CITY OF ALBUQUERQUE

**Re: New Mexico Educators Federal Credit Union, 2801 Juan Tabo Blvd NE,
Grading and Drainage Plan
Engineer's Stamp dated 10-09-06 (H21-D20)**

**Re: New Mexico Educators Federal Credit Union, 2801 Juan Tabo Blvd NE,
Grading and Drainage Plan
Engineer's Stamp dated 9-22-06 (H21-D20)**

SHEET TITLE
DRAINAGE PLAN

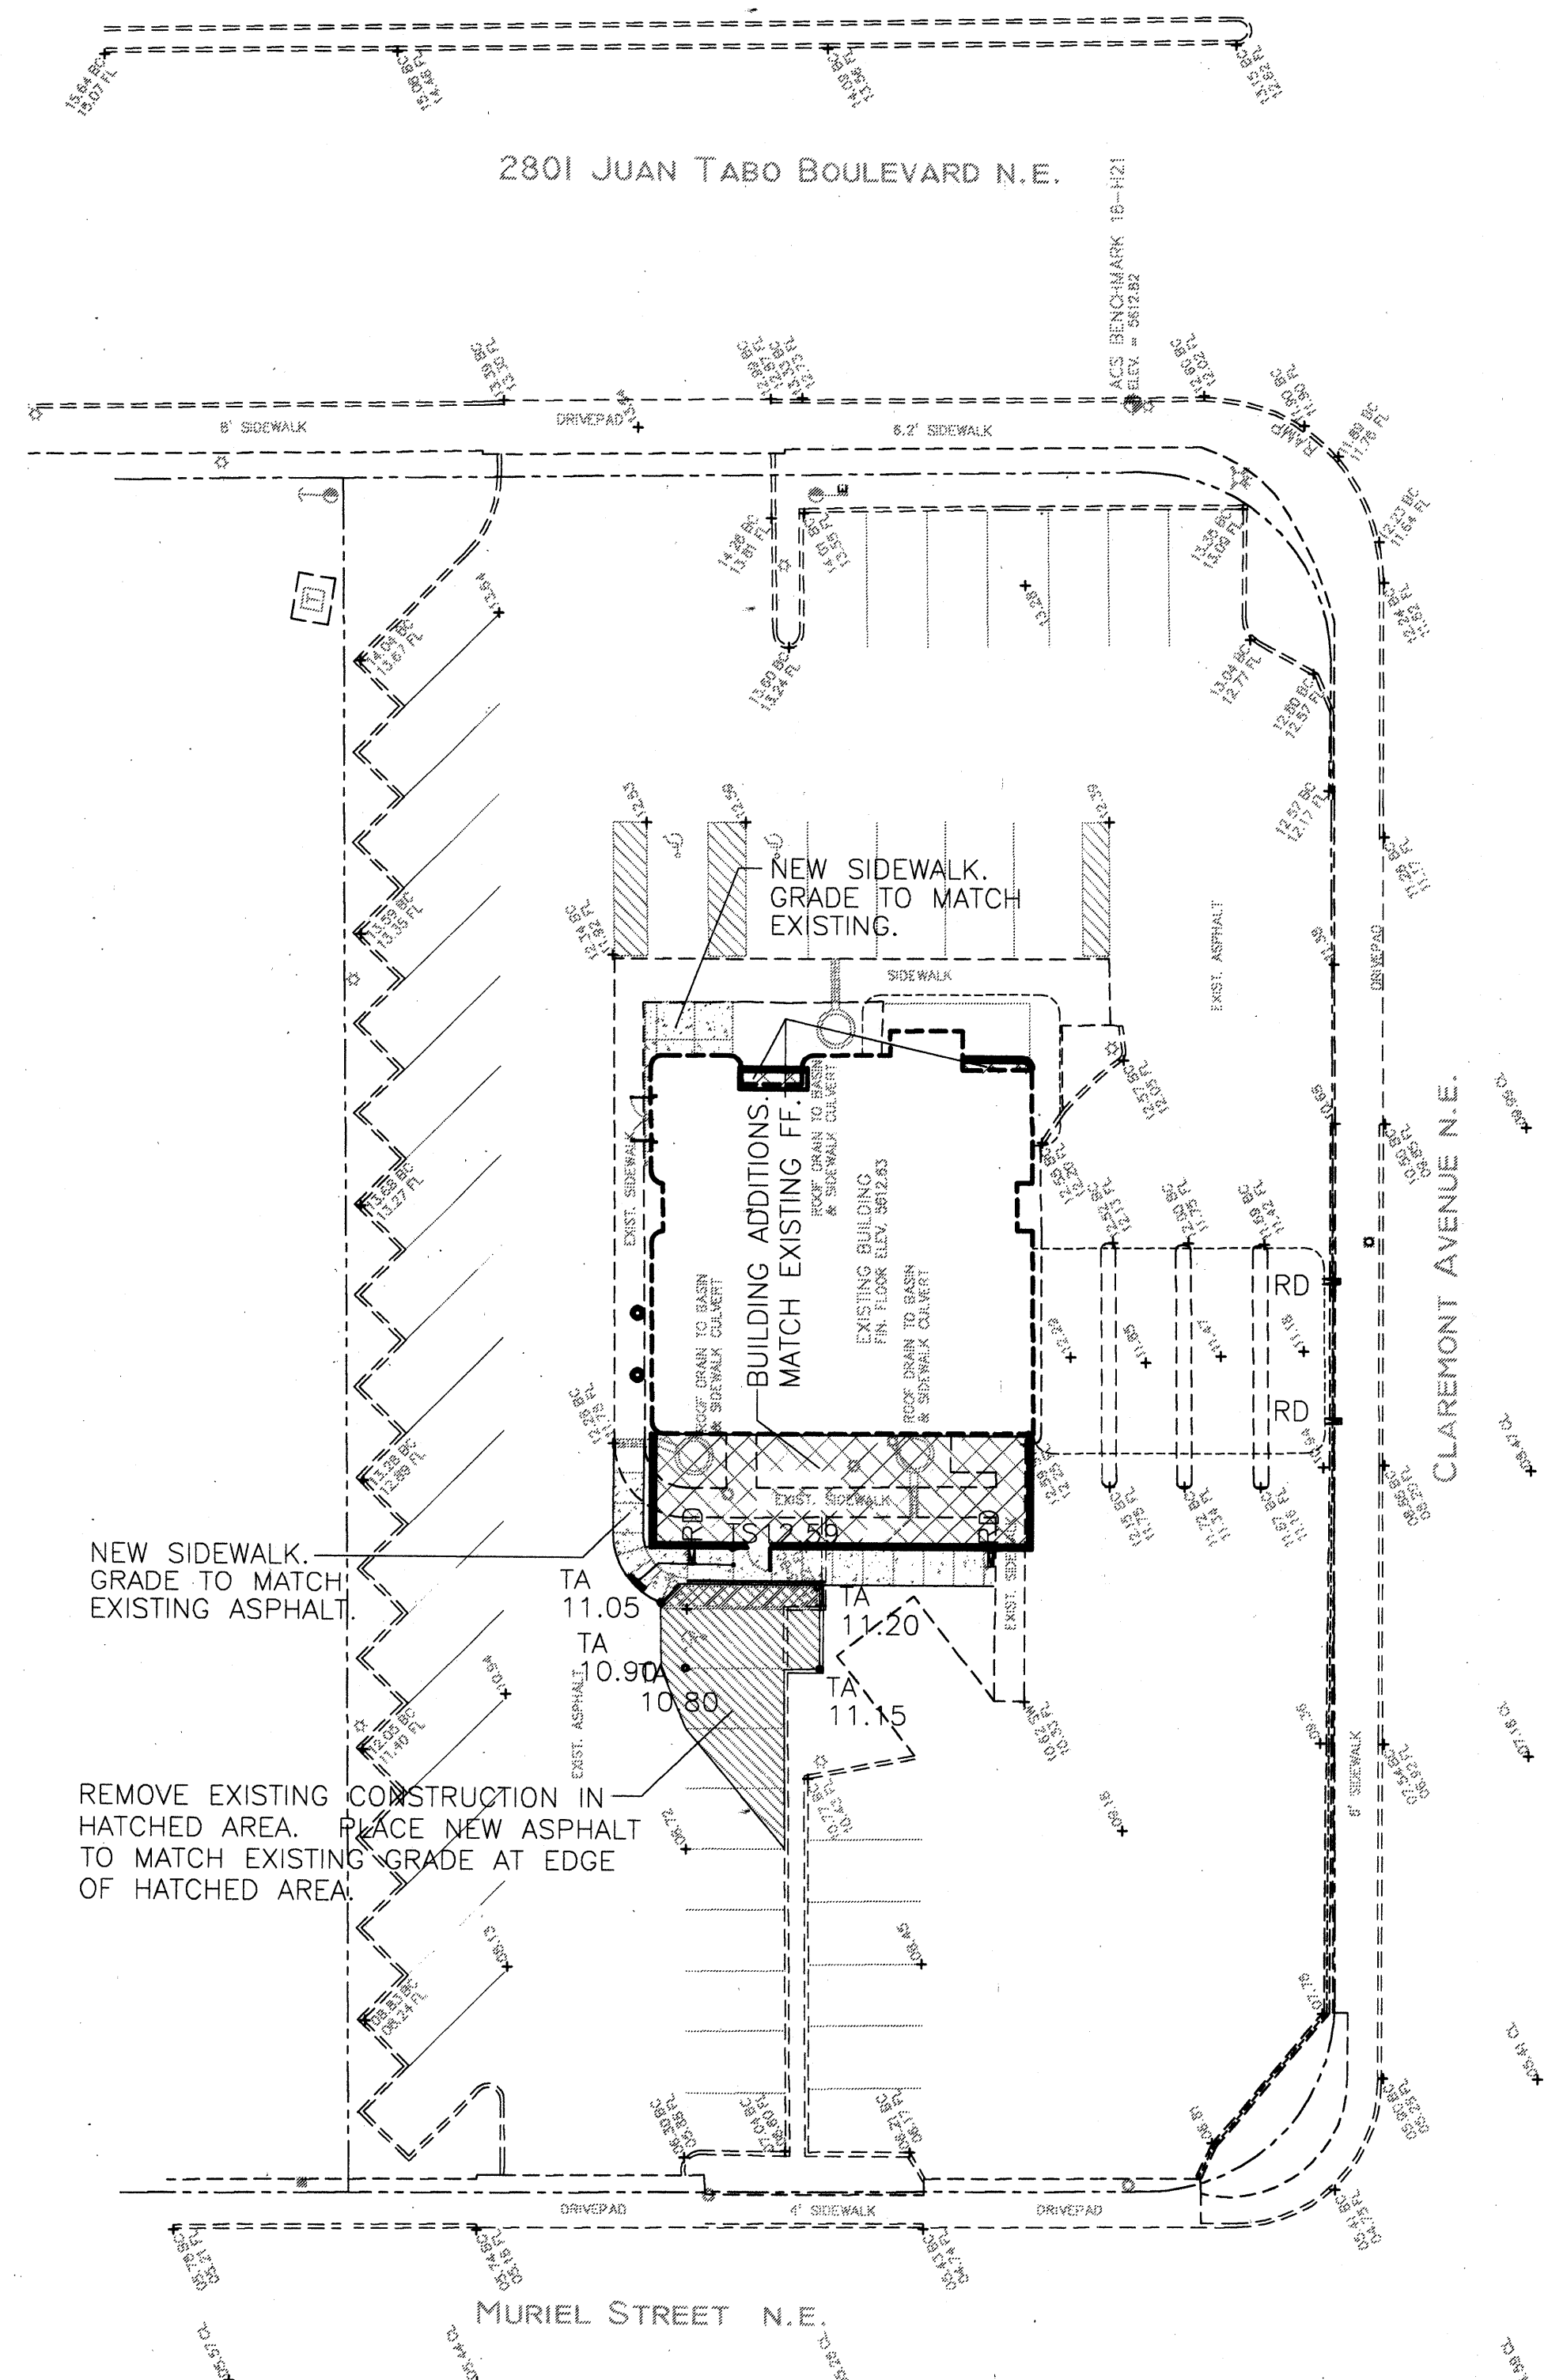
1. The scale is defined as 1"=20', but does not match the scaling bar provided. Please correct this.
2. The existing elevations shown are difficult to read.
3. Provide the finished floor elevation for the existing and proposed building.
4. Show the roof flows.

1. The scale bar and the drawing have been reconciled.
2. Existing elevations have been enlarged by 50%.
3. The existing FF elevation has been made more obvious and the additions have been shown as having the same elevation.
4. Roof slope directions have been shown on the plan.
